**Consultation Response from KC,
Trees**

2024/91591 Land off, Bankwood Way, Birstall Retail Park, Birstall, Batley, WF17 9DT

Variation conditions 2-6, 15, 29 on previous permission 2021/92528 for erection of retail development, associated parking, servicing areas and landscaping

Date Responded: 19/08/2024

PROPOSED SITE/SURFACING PLAN - PLANNING

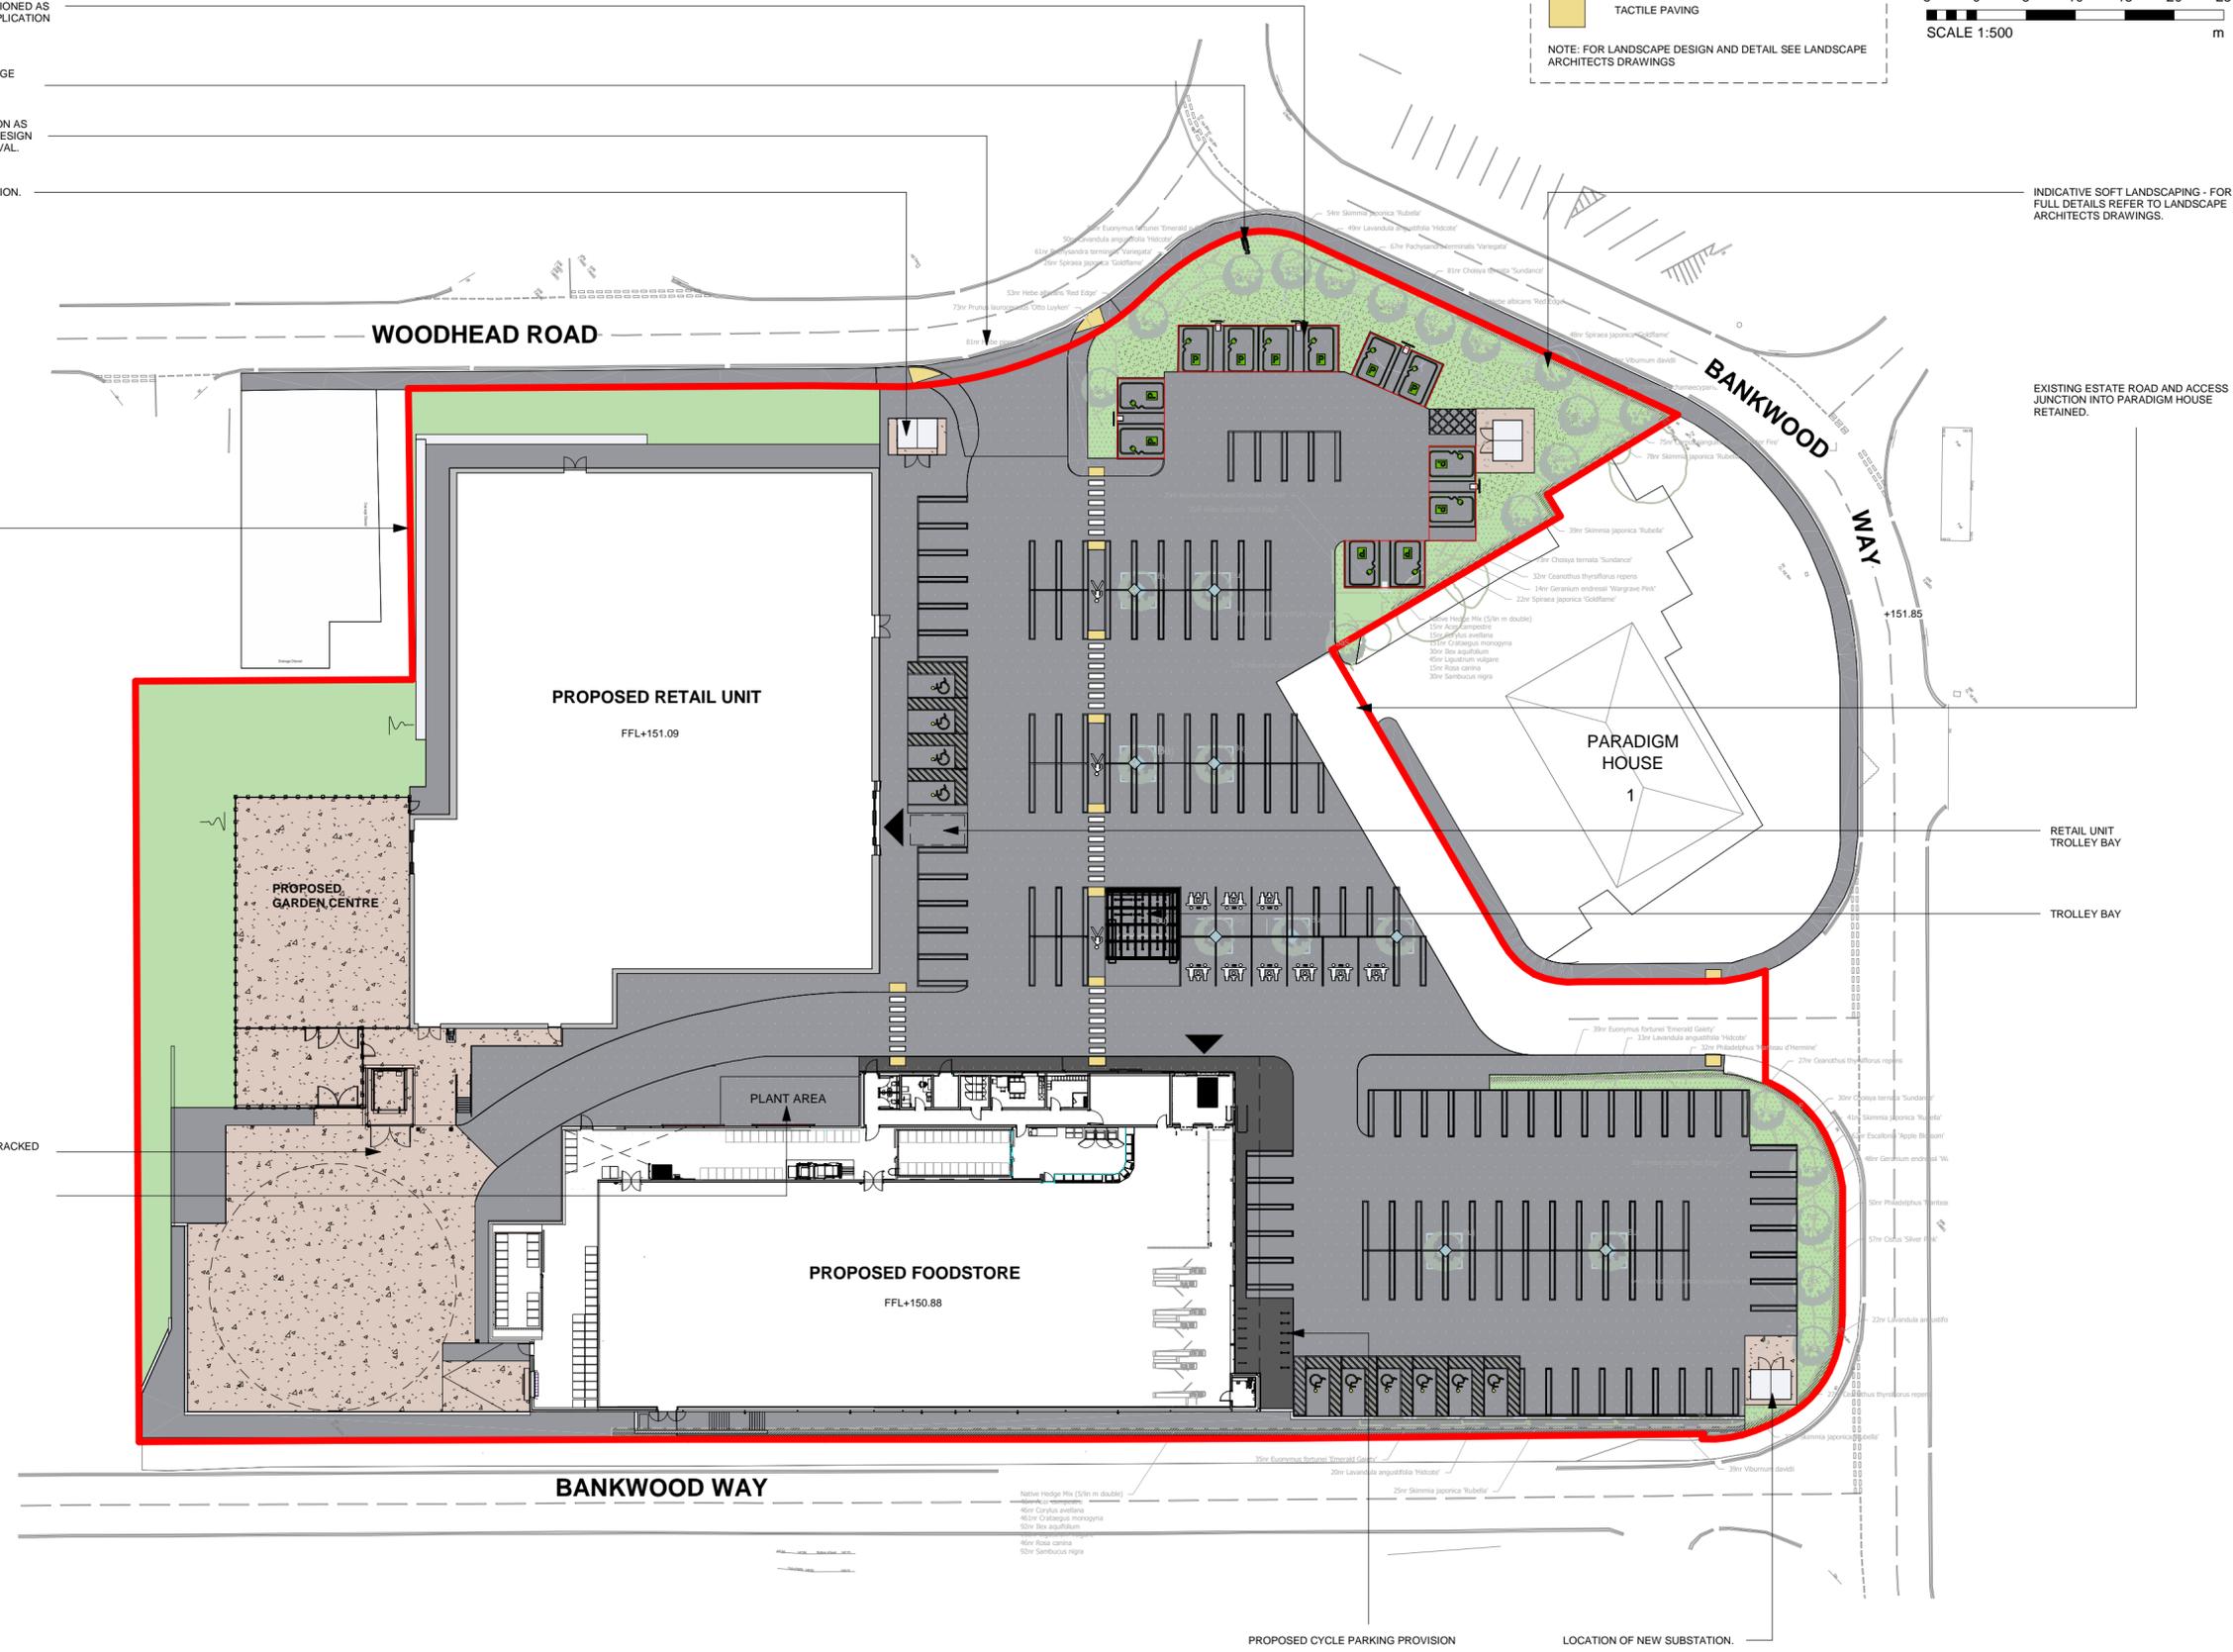
As stated by the previous tree officer, It is unclear why the existing boundary trees have to be removed, with a slight re-design of the car park, and use of specialist arboricultural construction methods, many could be retained. Many of these trees are an attractive feature of the locality and their loss would not meet LP 24 and LP33.
